Submission Form

Epping to Thornleigh Third Track Proposal. Application number SSI 5132.

I/we object to the Epping to Thornleigh Third Track Proposal and consider that the EIS is inadequate and does not address the full impact of this proposal. It will cause untold damage to the health of residents and to the fabric of the Beecroft Cheltenham Heritage Conservation Area. Do not approve this project, reconsider the alternatives and protect the community.

Figure 5.5 Extent of proposed construction works in the vicinity of Beecroft Station

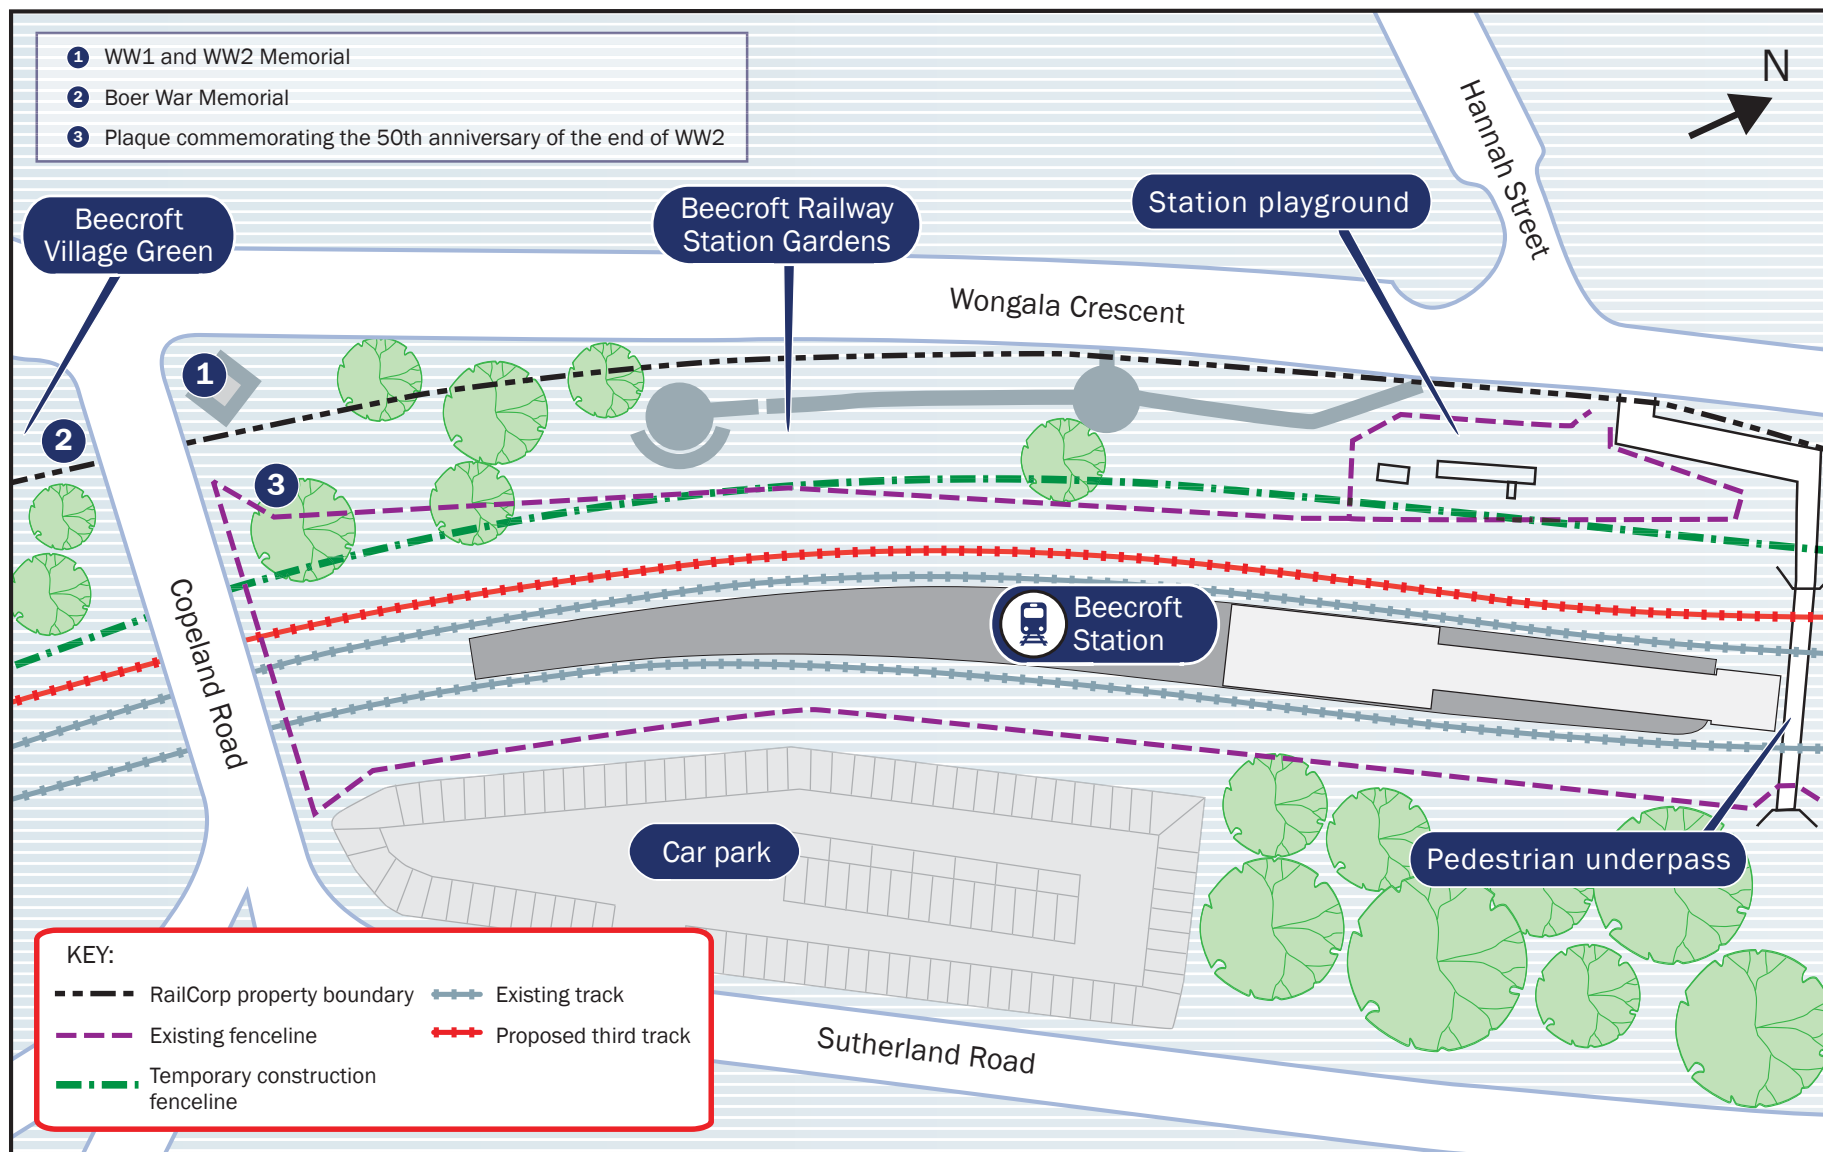
- There has been inadequate assessment of the project's impact on the fabric of the Beecroft Cheltenham Heritage Conservation Area (HCA).
- The plan given for Beecroft Railway station Precinct is vague. The relationship to the trees, playground and original 1895 platform located south of the present station is not shown. A fourth track is shown on the eastern side. The plan does not include urgently needed lifts to allow disabled access at Beecroft Station.

- Beecroft Station Gardens have a heritage listing with Hornsby Council but the impact on them has not been adequately addressed. No arborist's report is given for the trees which will be removed.
